PROJECT NO. PR-2021-002309

DESCRIPTION: Reponse Letter, Plat, Revised infrastructure lists, Access exhibit

**RE: LA MIRADA SUBDIVISION
PRELIMINARY PLAT AND SITE PLAN
DRB PROJECT NUMBER: 2021-002309**

Per the correspondence via email of Ms. Jeanne Wolfenbarger, PE, City of Albuquerque Development Review Board Transportation Comments, dated September 29, 2021, please find the following responses addressing the comments listed below:

**Preliminary Plat for
Wymont Subdivision
Being Comprised of
Lot 1-A-1, La Mirada Subdivision
City of Albuquerque
Bernalillo County, New Mexico
August 2021**

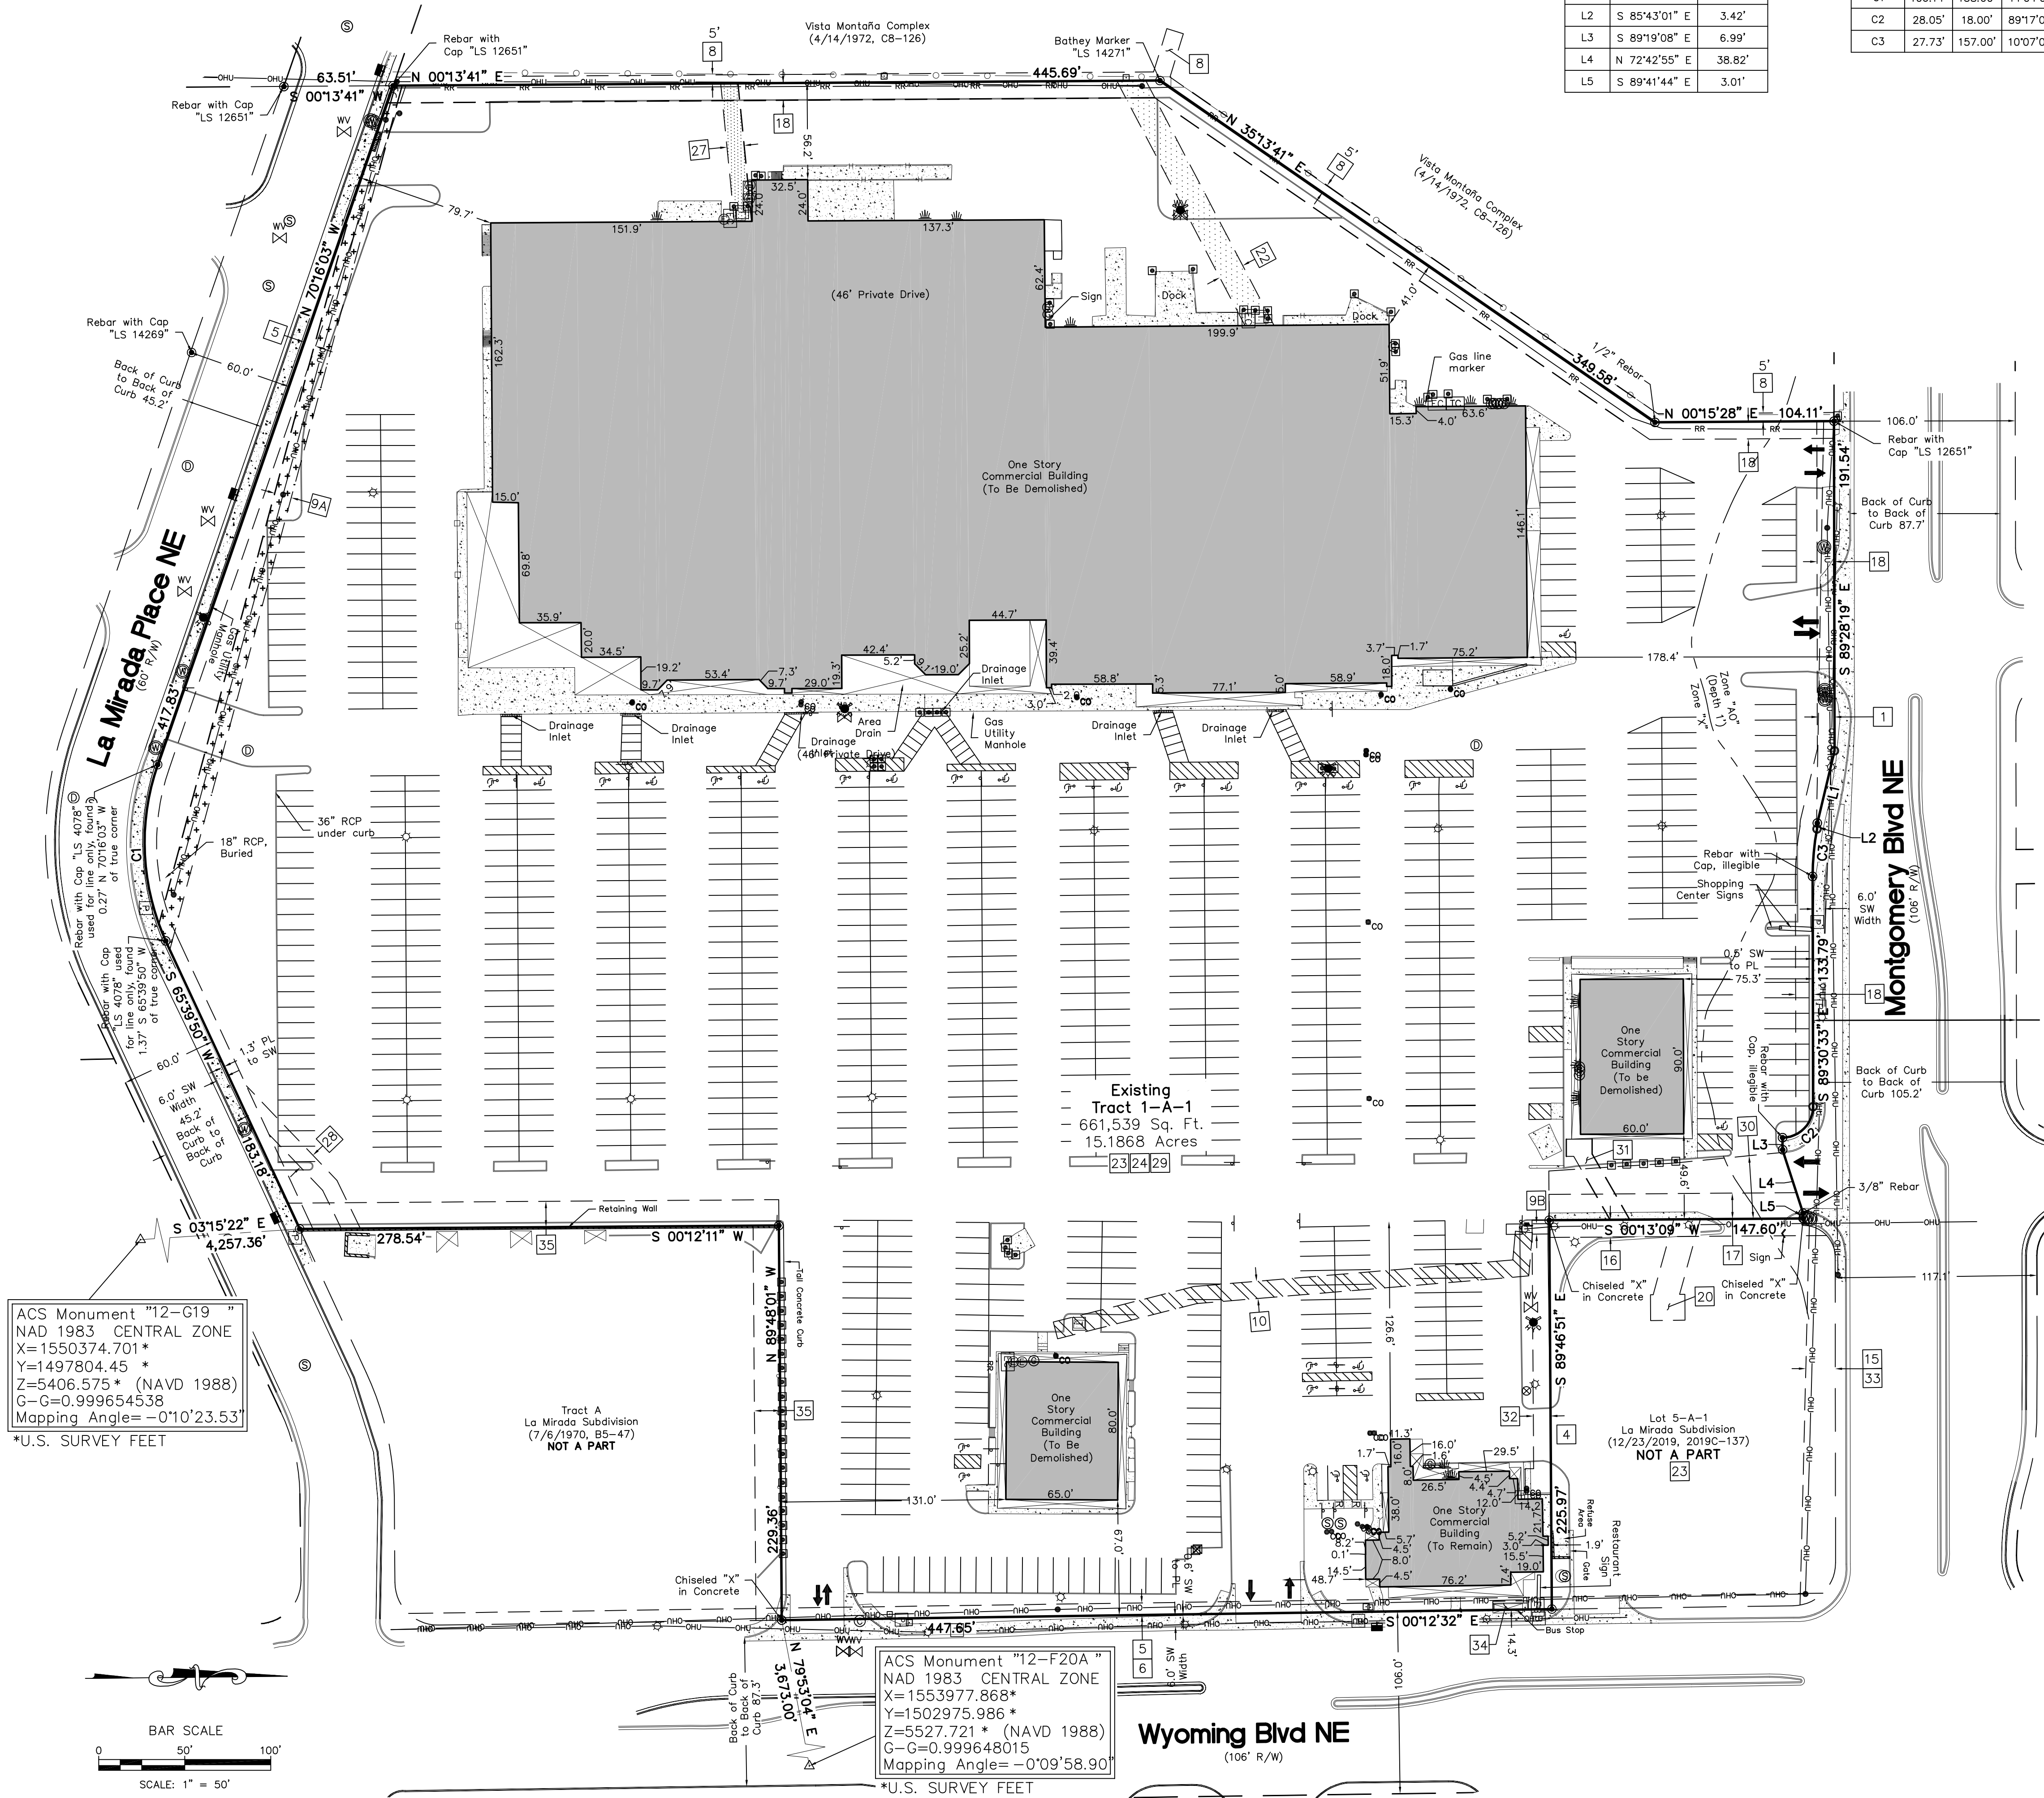
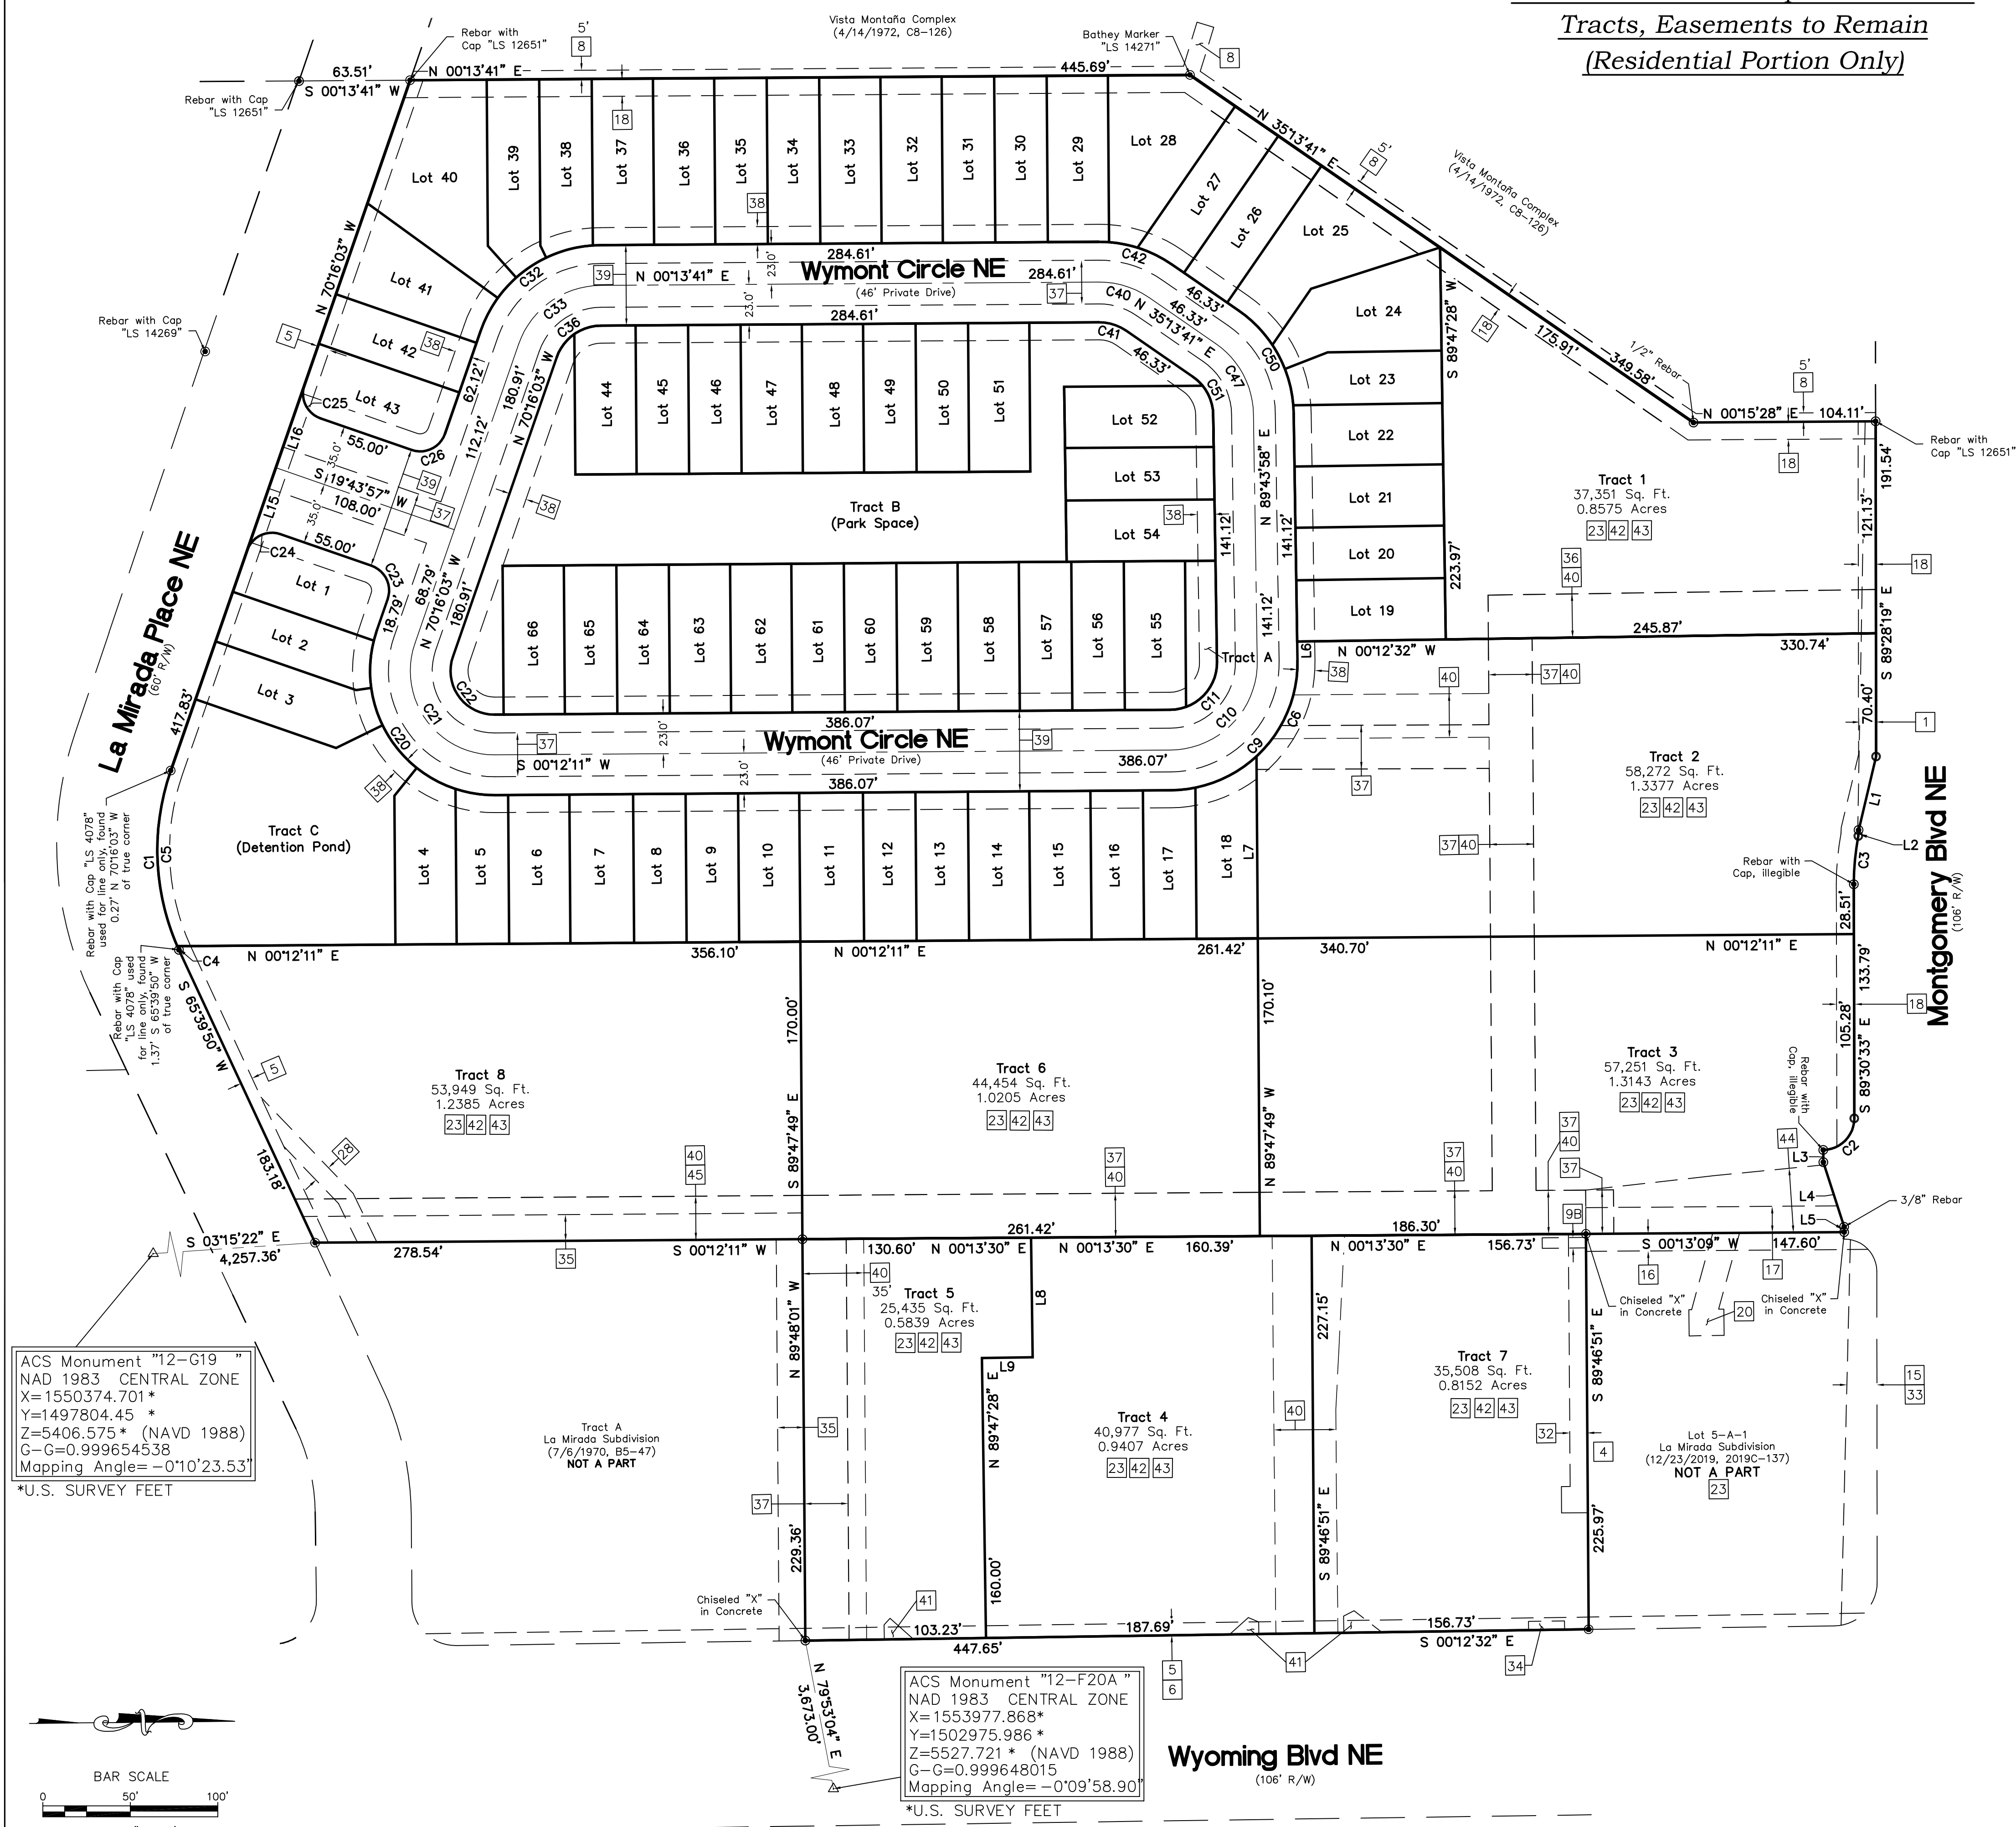
11. In lieu of labeling "R/W", label "Easement" for the private roadway for the residential subdivision.
The private roadway is shown as its own Tract on the plat and includes a private access easement.

1. Wymont Circle should be its own Tract which is owned by the HOA and should be a private drainage easement.
Wymont Circle is shown at Tract D on the plat.

ENGINEER'S SEAL	THE WYMONT ALBUQUERQUE, NM	DRAWN BY pm
	VEHICLE AND PEDESTRIAN CONNECTIVITY EXHIBIT	DATE 8-16-21
RONALD R. BOHANNAN P.E. #7868	TIERRA WEST, LLC 5571 MIDWAY PARK PL NE ALBUQUERQUE, NEW MEXICO 87109 (505) 858-3100 www.tierrawestllc.com	DRAWING
		SHEET # 1
		JOB # 2021008

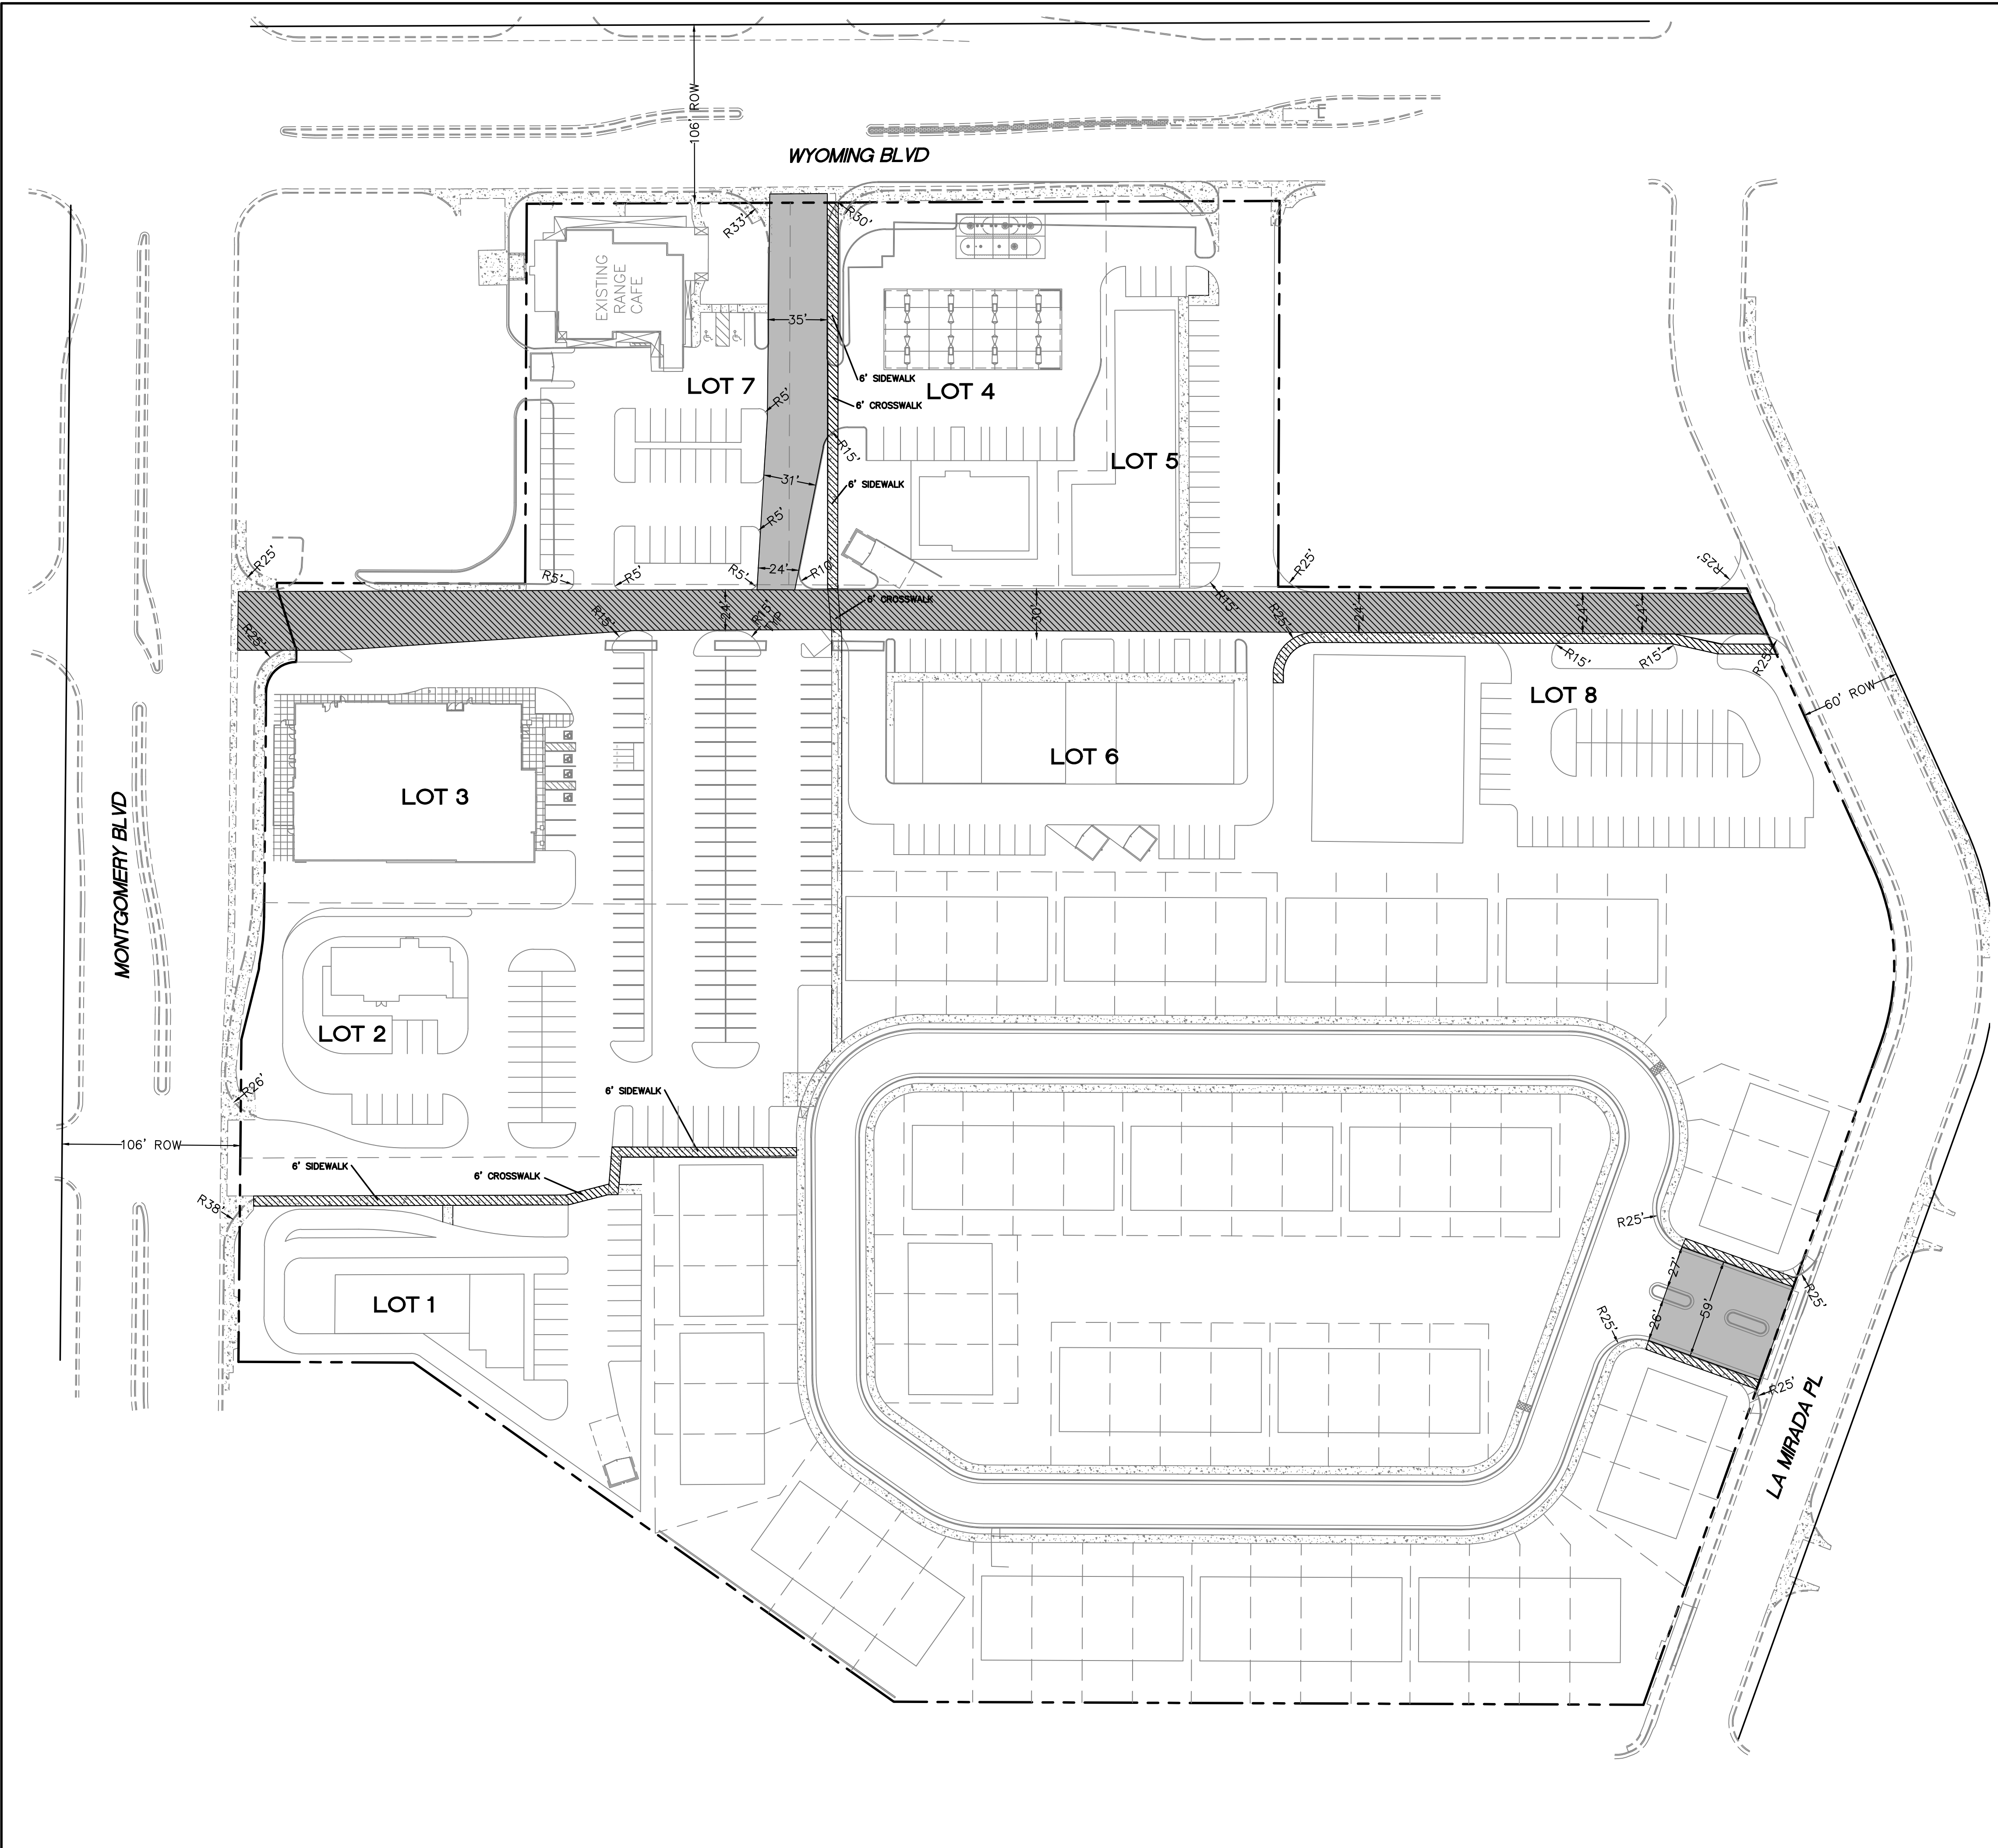
4. Provide road cross-sections for internal roadway network within commercial part of the site. Roadway easements shall include the pedestrian ways shown on the exhibit for pedestrian ways that serve multiple lots. Overlay easement limits on the roadway exhibit.
The cross-sections were added to the exhibit which is attached to this resubmittal. The easements are shown as well.
